Ref: 6/2023/2418/OUTLINE
Date: 11/04/2024

HISTORIC BUILDINGS AND CONSERVATION ADVICE

RE: Former Hook Estate and Kennels, Coopers Lane Road/Firs Wood Close, Northaw EN6 4BY

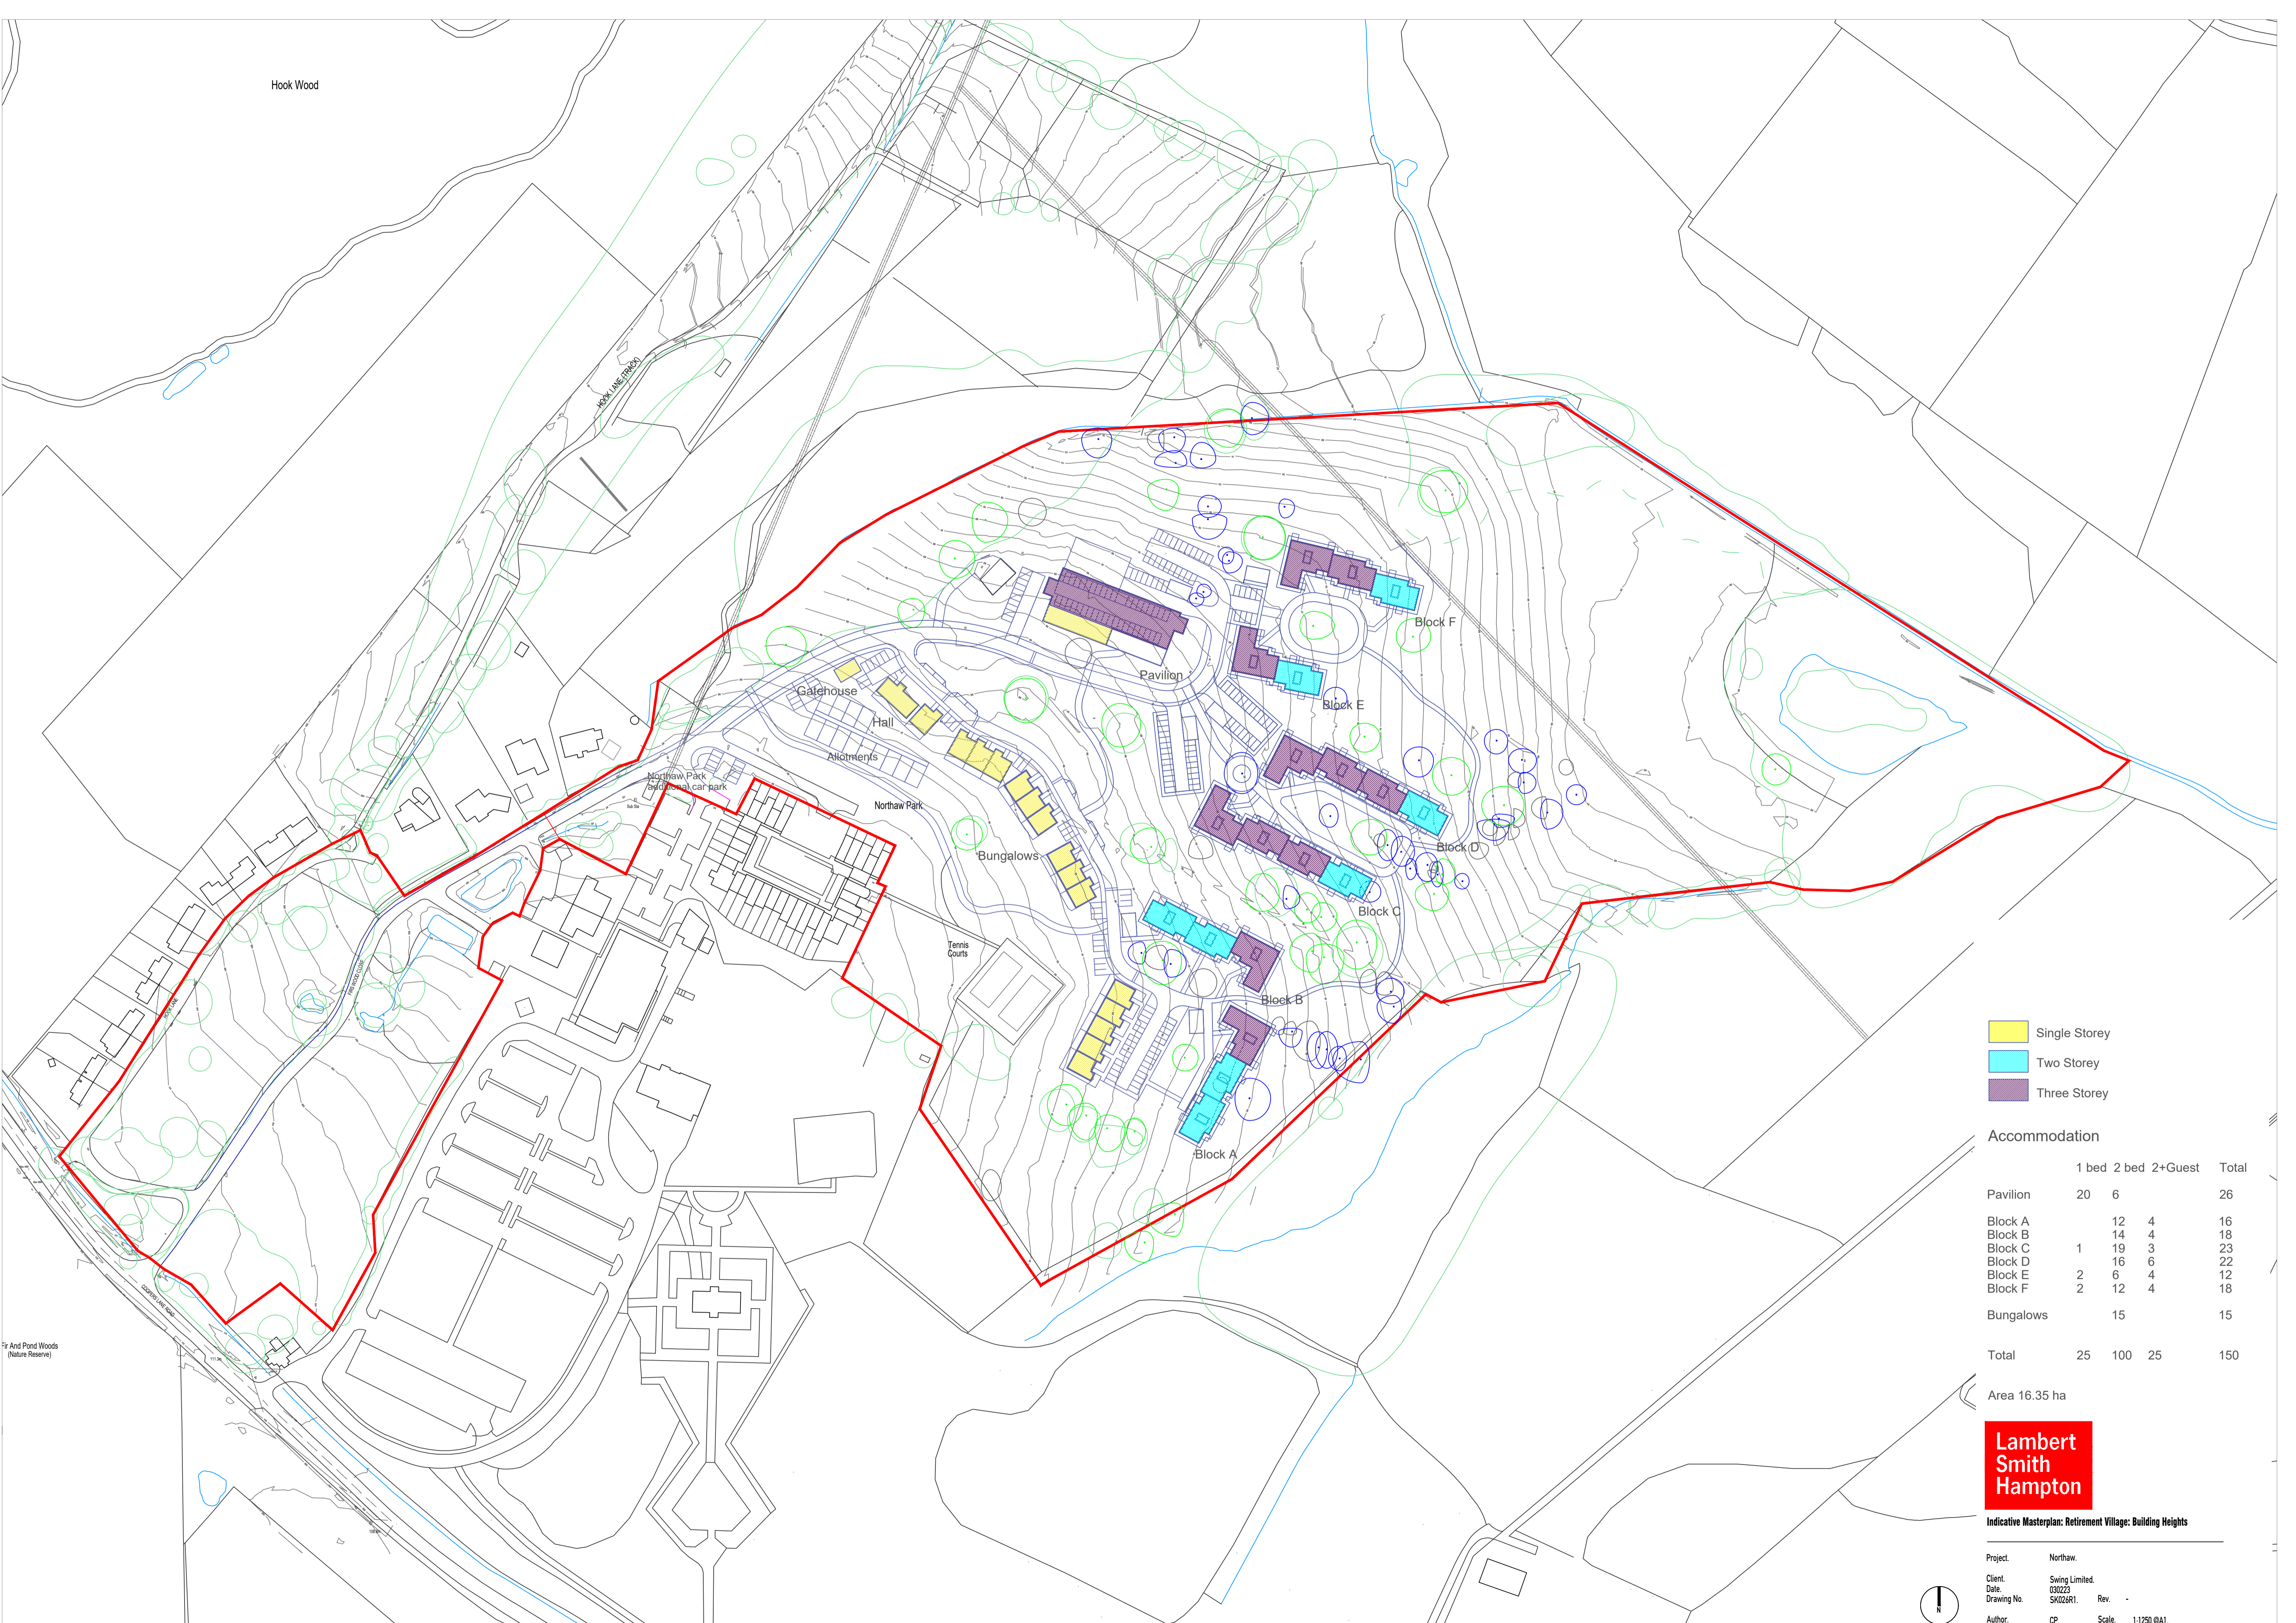
Furthermore, the parameter plan indicates that the single storey dwellings would be approximately 7m above ground level (which is comparable with the height of a two-storey dwelling), the two storey dwellings being 10.5m and three storey dwellings being 13.5m in height. There are concerns that the proposed development may still be visible above the height of most existing trees.

As observed on site, the land levels of the application site slope quite steeply away from the listed building and utilising the topography of the land to minimise the visual impact (as proposed to have the lowest buildings closest to the listed building and the taller buildings further north where the land levels drop). However, no site sections have been submitted or indicative wirelines of building height parameters. This makes it difficult to understand how the development would sit within the landscape.
